Planning
Ask for: Wendy Lane
Telephone: 01474 33 74 01
Email: wendy.lane@gravesham.gov.uk
My ref: Tilbury2
Your ref: TR030003
Date: 17 August 2018

Draft Tilbury 2 DCO requirement in relation to operational noise

**NOISE MONITORING LOCATION PLAN**

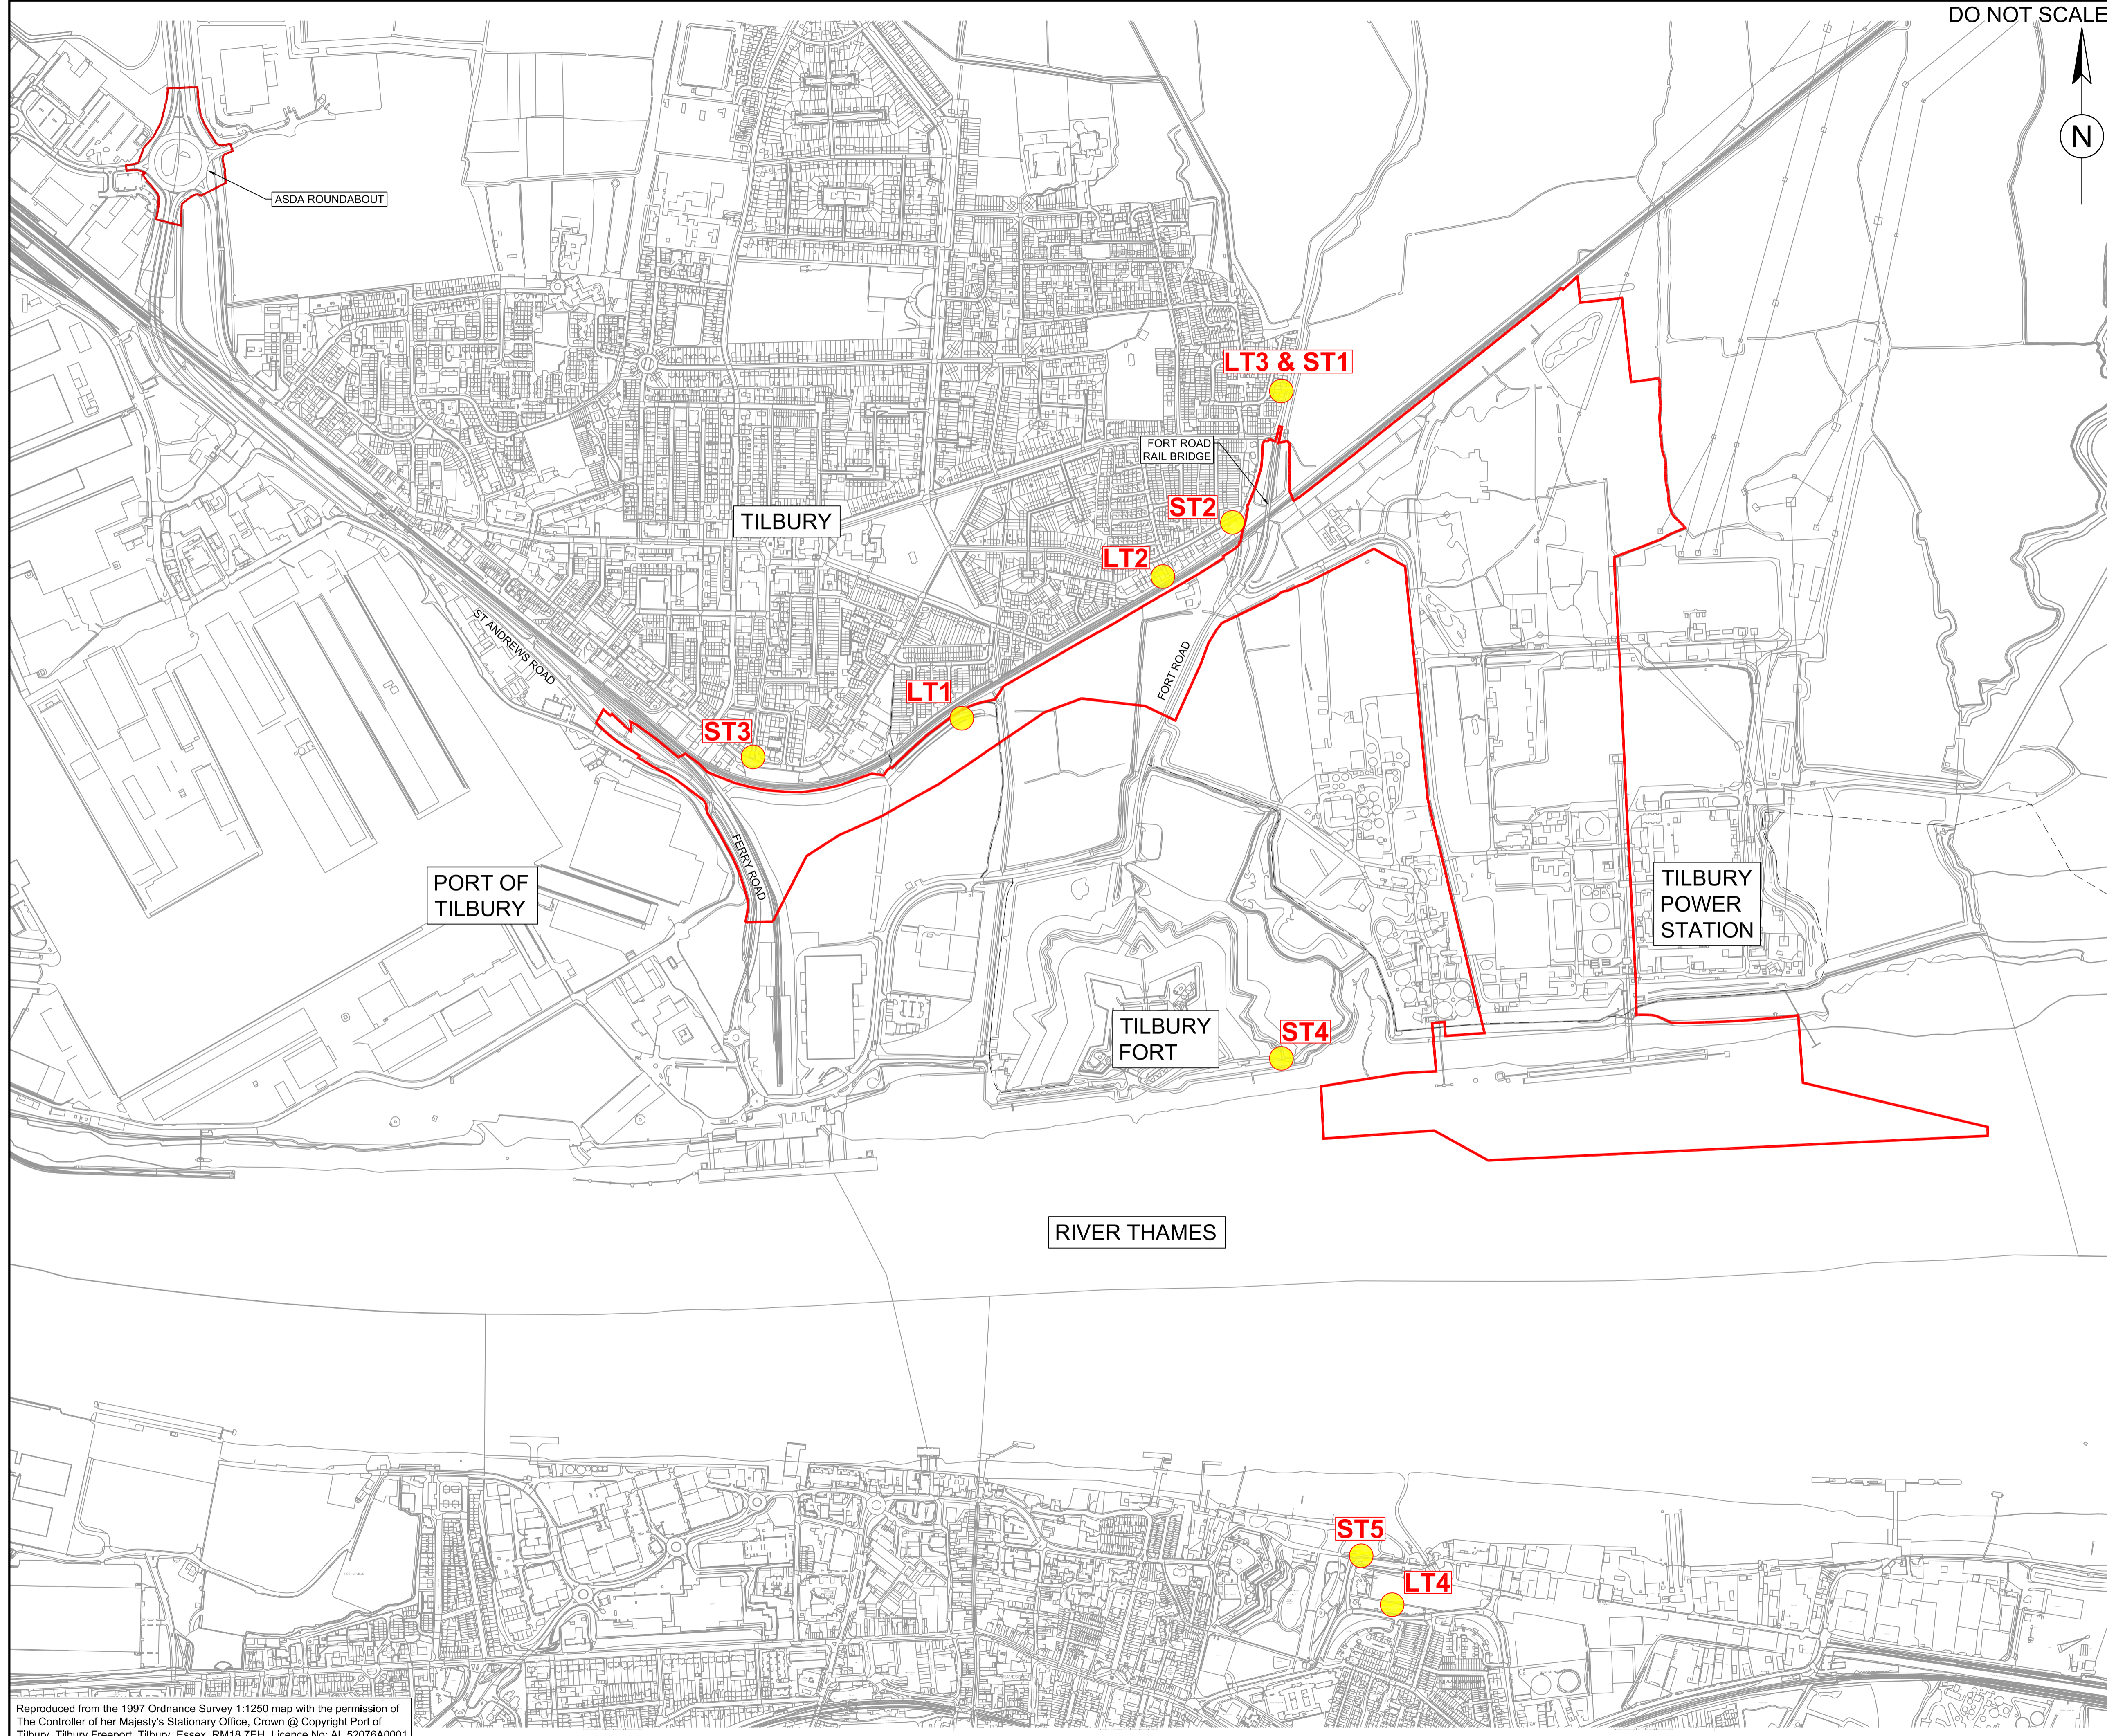
For the sake of completeness, in terms of monitoring points to be agreed under (i) above, GBC's deadline 6 response anticipated that these would be in the same short-term and long-term locations as set out in the ES. It is also assumed by GBC at that stage this would include locations identified for the measurement of background noise for a period of not less than 6 months ending not later than the time when construction on site commences.
